Ribble Valley Borough Council
Planning Section
Council Offices
Church Walk
Clitheroe
BB7 2RA

Planning application no.: 3.24.592

Location: 6 Railway View Road, Clitheroe

Proposal: Proposed new ramped pedestrian access with handrail to front and alterations to front door. Conversion of roofspace and new velux rooflight to rear.

Drawing Title
Build Regs: Section and Ramp Details

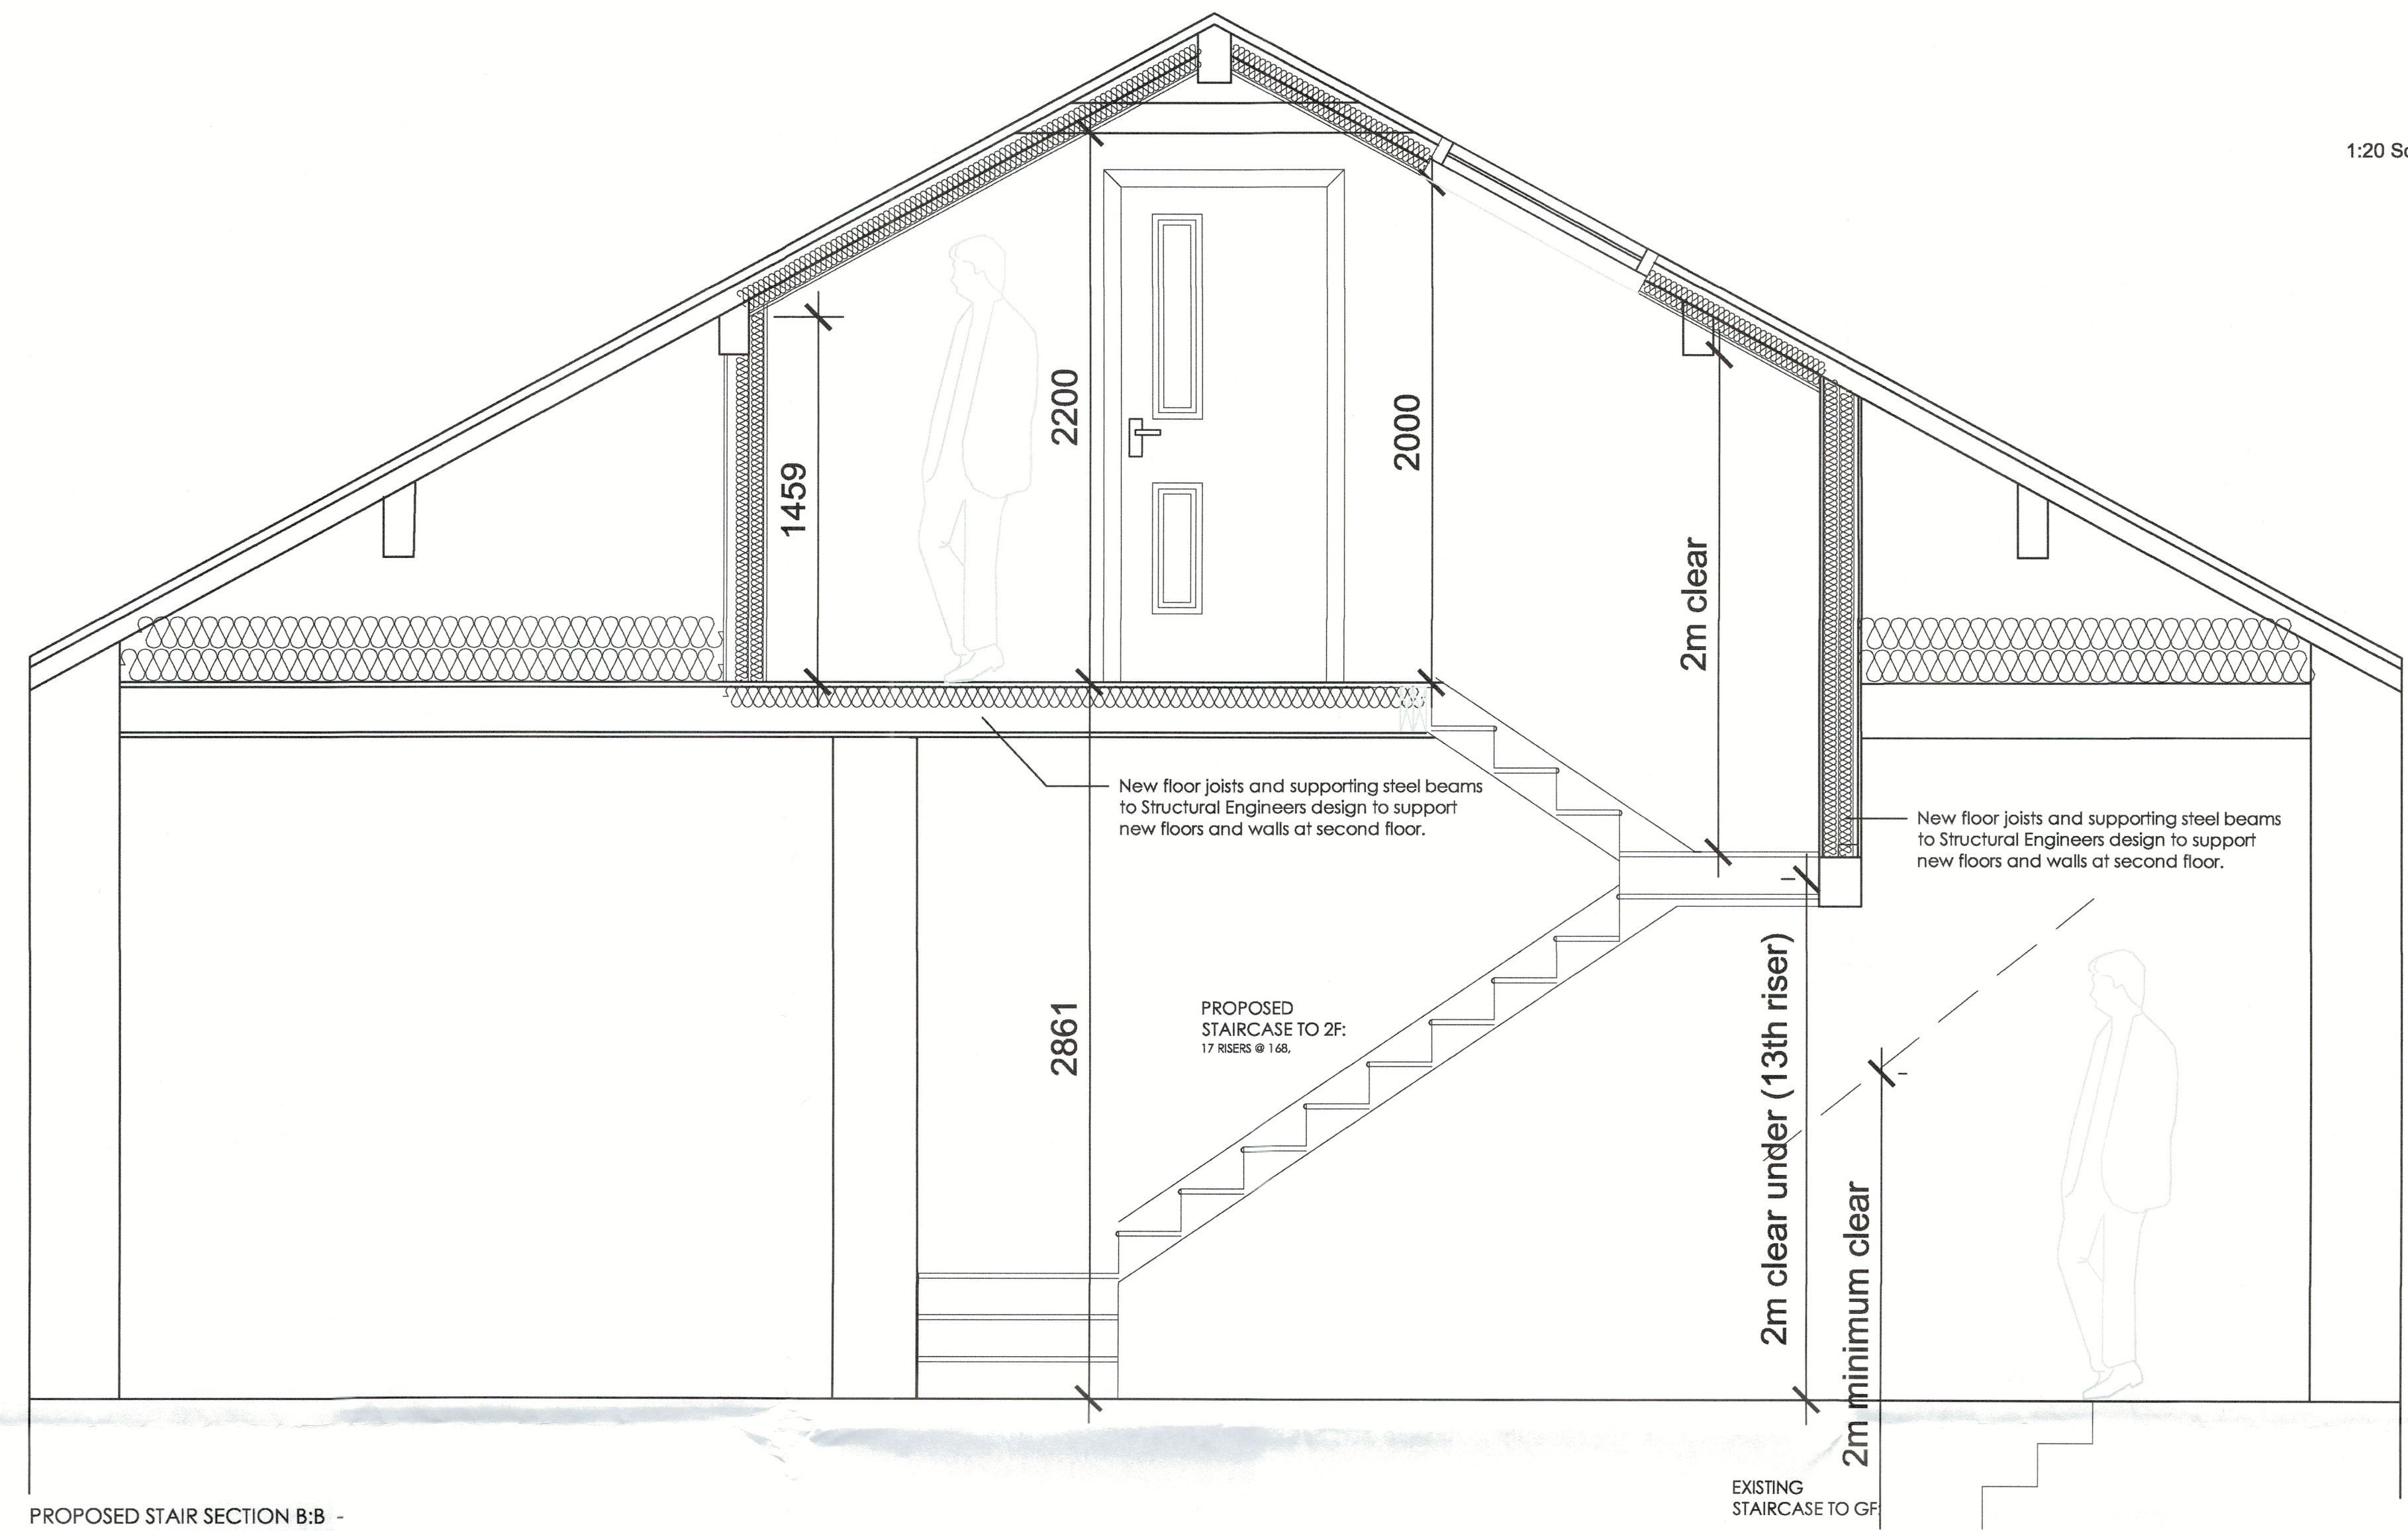
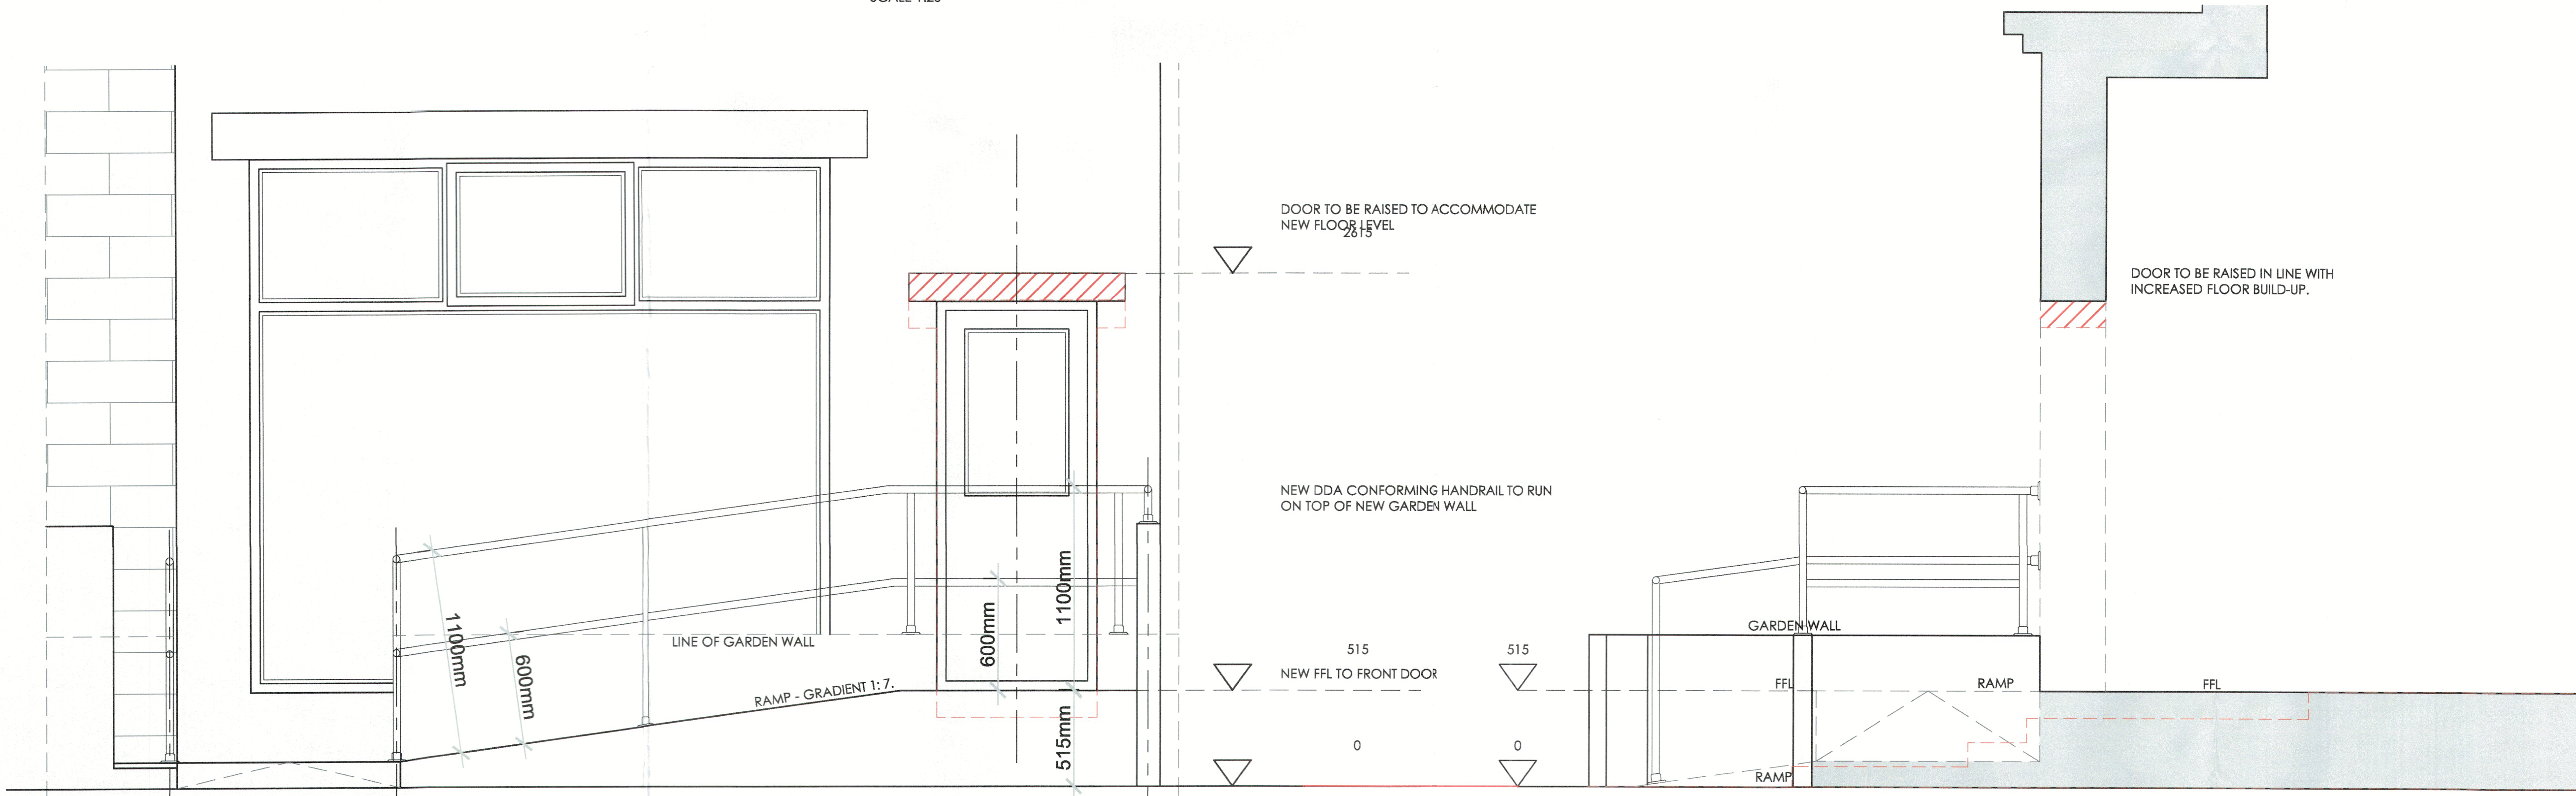
The LHA will also condition that a suitable drainage strategy is provided following the proposal, with the LHA being concerned that any surface water from the ramped access may drain onto the adopted highway. To prevent this the LHA advise that an access drain is provided along the site frontage to collect the surface water before it enters the adopted highway.

The surface water from the approved access shall be collected within the site and drained to a suitable internal outfall.
